# CATHEDRAL PINES SUBDIVISION FILING NO.2, LOT 51

## AN AMENDMENT TO LOT 51, CATHEDRAL PINES SUBDIVISION FILING NO.2

# Markup Summary

CATHEDRAL PINES SUBDIVISION FILING NO.2, LOT 51

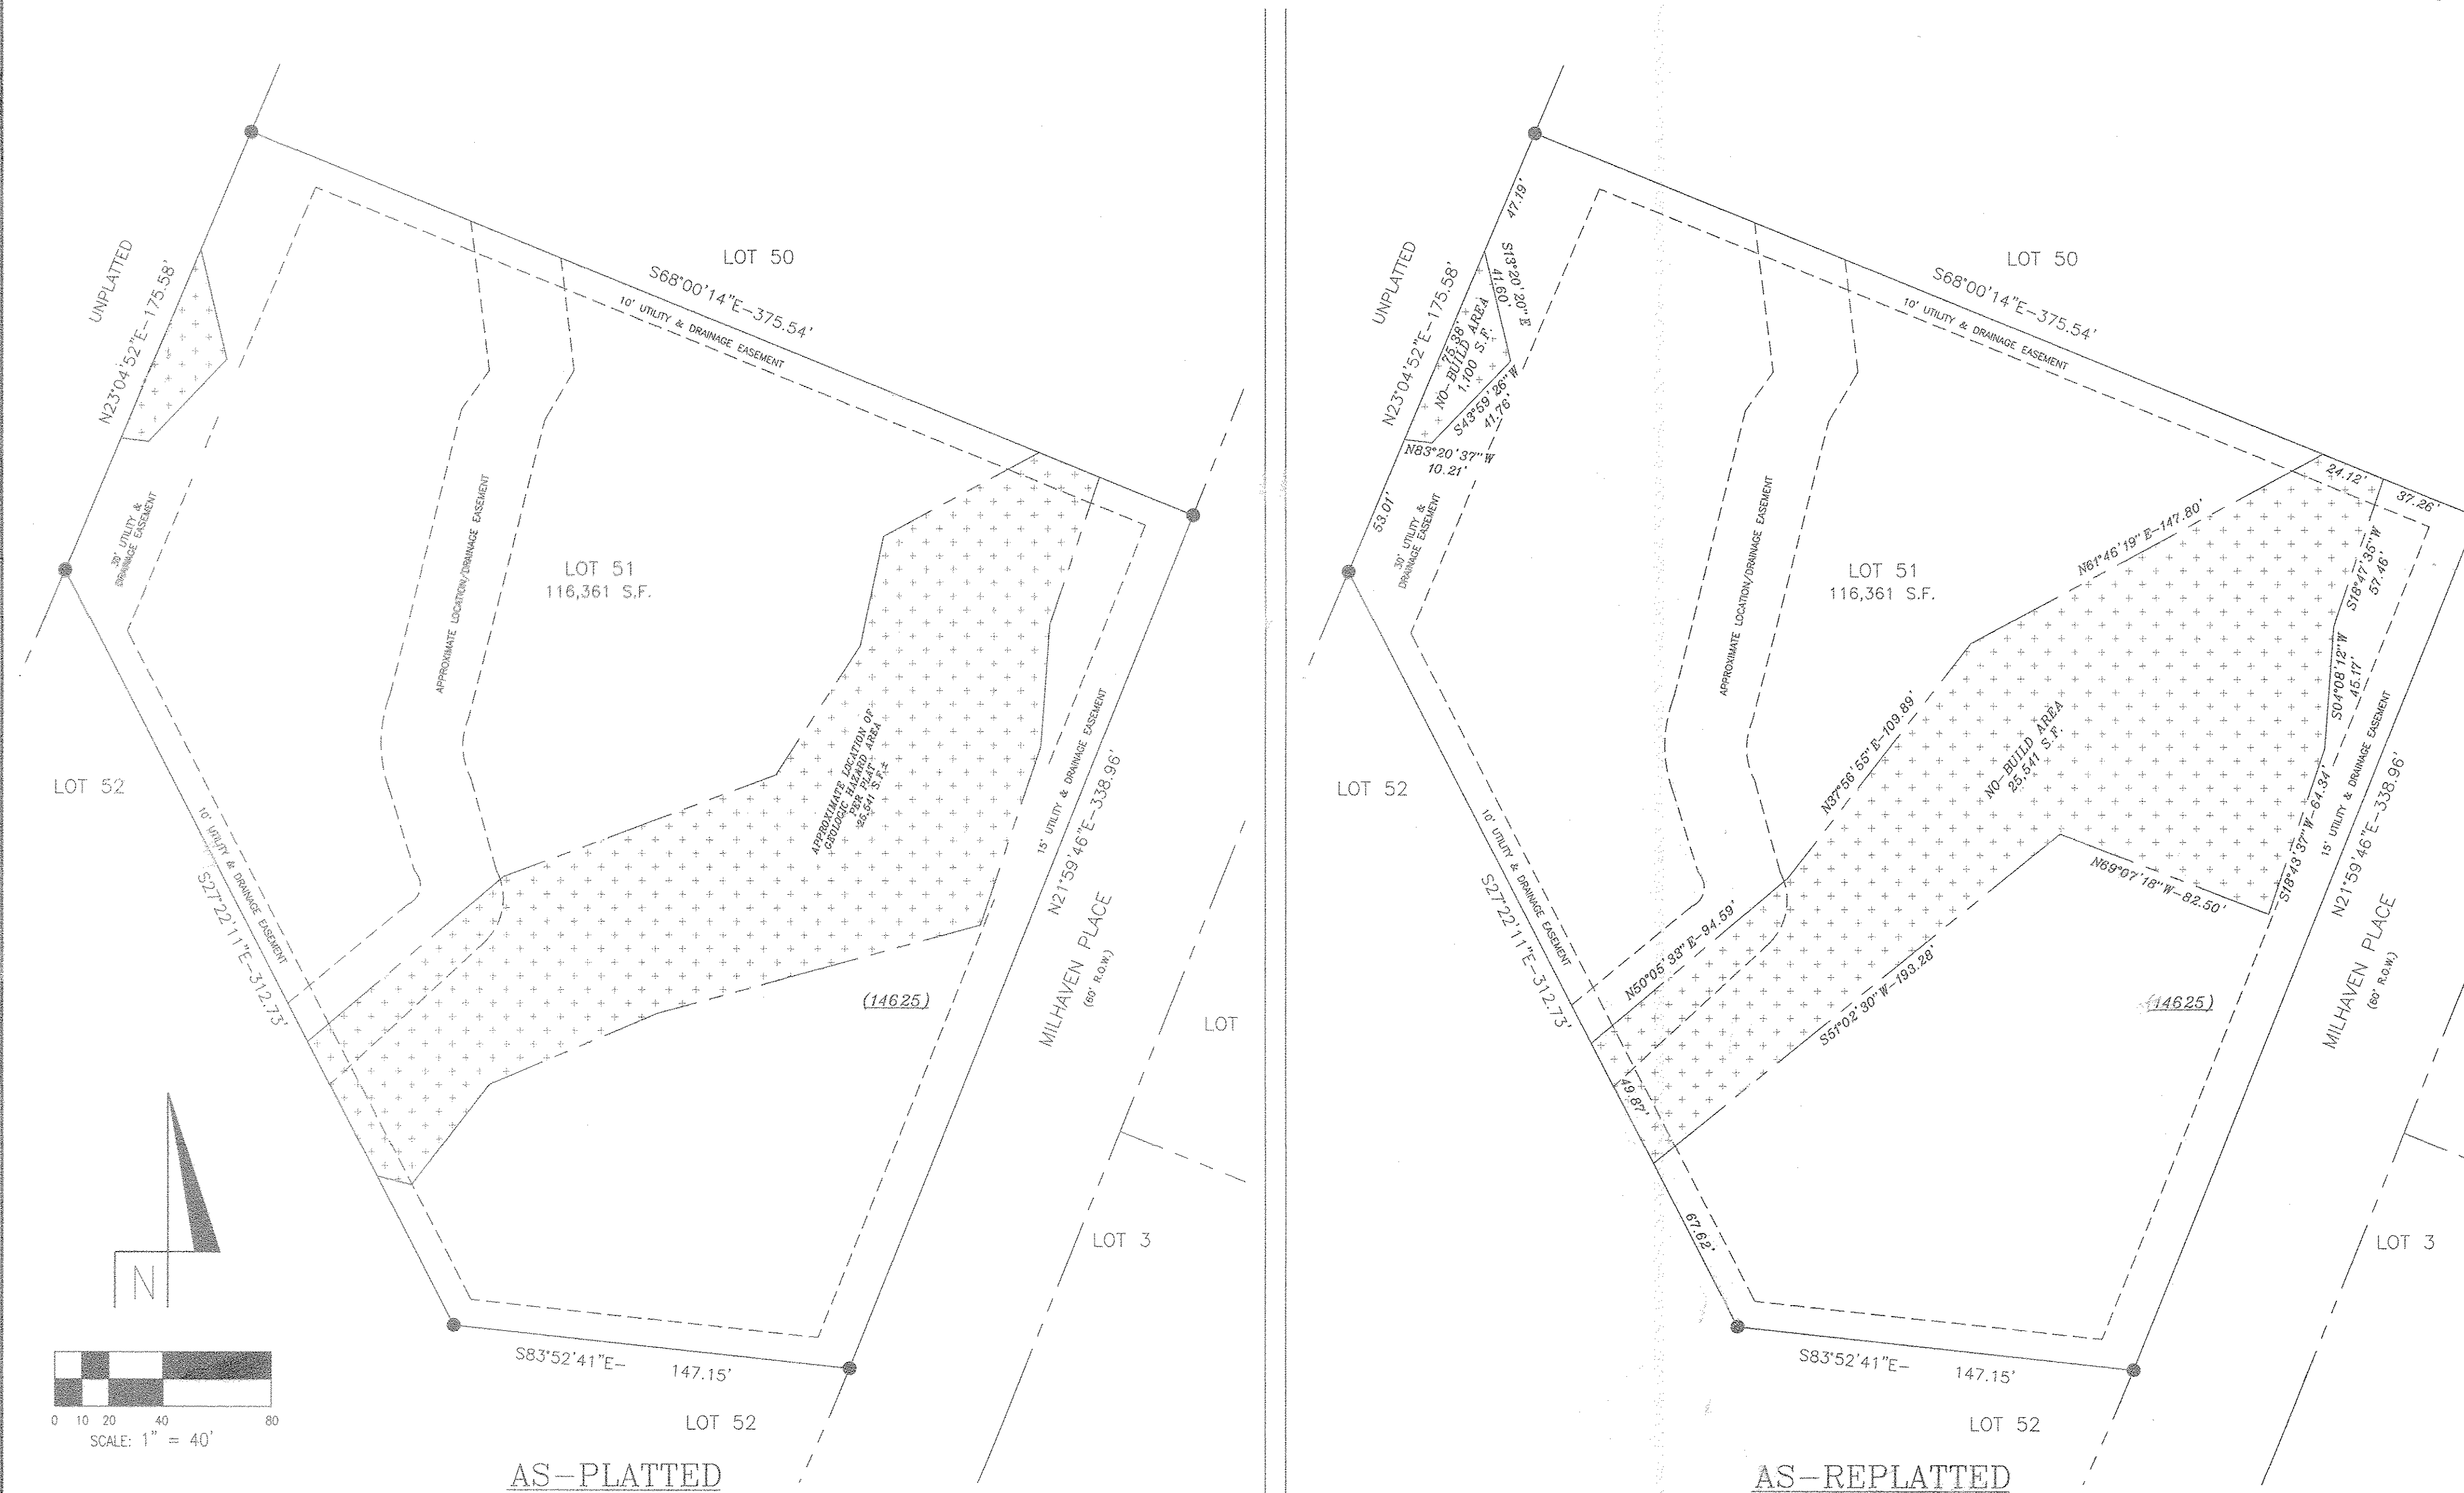
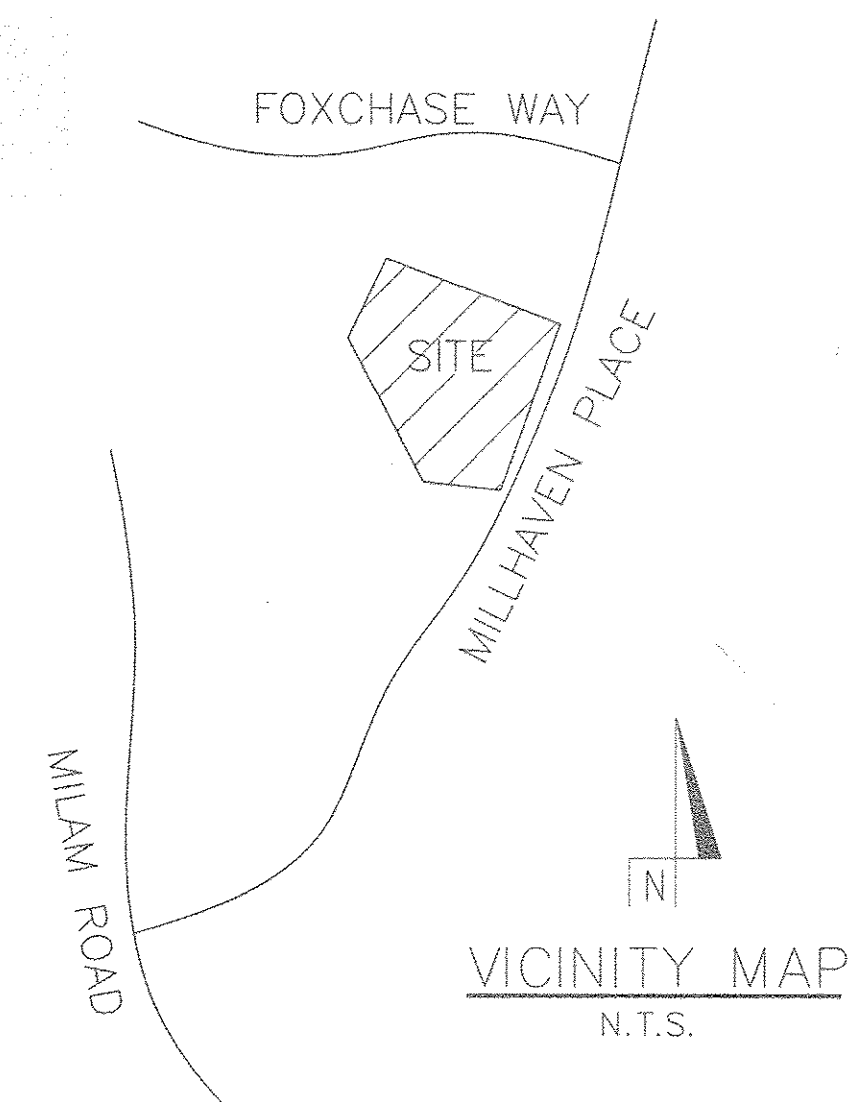
The vacate replat cannot be scheduled for approval until notes below have been added to plat

lot still a part of the SIA agreement, note required

this note clearly states any owner or successor has the responsibility to notify the hoa and future owners, note required

The augmentation plan is still required to be noted on this plat, as the well is still a part of that augmentation plan, note required

This lot is still subject to the PUD Development plan, note required

note required for any future development on lot, note required

The original Note 14 (new note #19) should remain as was requested from previously submitted Amended Plats in this area.

This advises all future owners of the requirements, note required

Having this note means that all future property owners, county staff, building department would have to reflect on two separate plats to make sure all standards are meant. It is the responsibility of the applicant at time of vacate replat to apply these notes or an approval may not be able to be done, any previously approved amendments does not warrant an approval of this application.

7. This is not a corner lot, this note does not apply to this lot. Refer to note 14 (new note 19.) Not added

10. This note is for the entire Development and not the individual Lot owners responsibility. These have already been completed by the Developer. Refer to note 14 (new note 19.) Not added

11. This note is for the entire Development and not the individual Lot owners responsibility. The Lot owner is responsible for thier own well only. Refer to note 14 (new note 19.) Not added

12. This note is for the entire Development and not the individual Lot owners responsibility. The Lot owner is responsible for thier own well only. Refer to note 14 (new note 19.) Not added

13. Note added as note #15

14. Note added as note #16

15. The PUD plan, Millam Road improvments are not the responsibility of the Lot owner. Refer to note 14 (new note 19.) Not added

16. Note added as note #17

18. This note pertains to the lots listed, this lot has already submitted this information for review and approval requiring this Amended Plat for this lot only. Refer to note 14 (new note 19.) Not added

19. Note added and note #18

20. This lot does not abutt Milam Road and is not required. Refer to note 14 (new note 19.) Not added

23. This is the Developers responsibility and not the individual Lot owner. These requirements have already been adheared to by the Developer or the sale of these individual lots would not be possible. Refer to note 14 (new note 19.) Not added
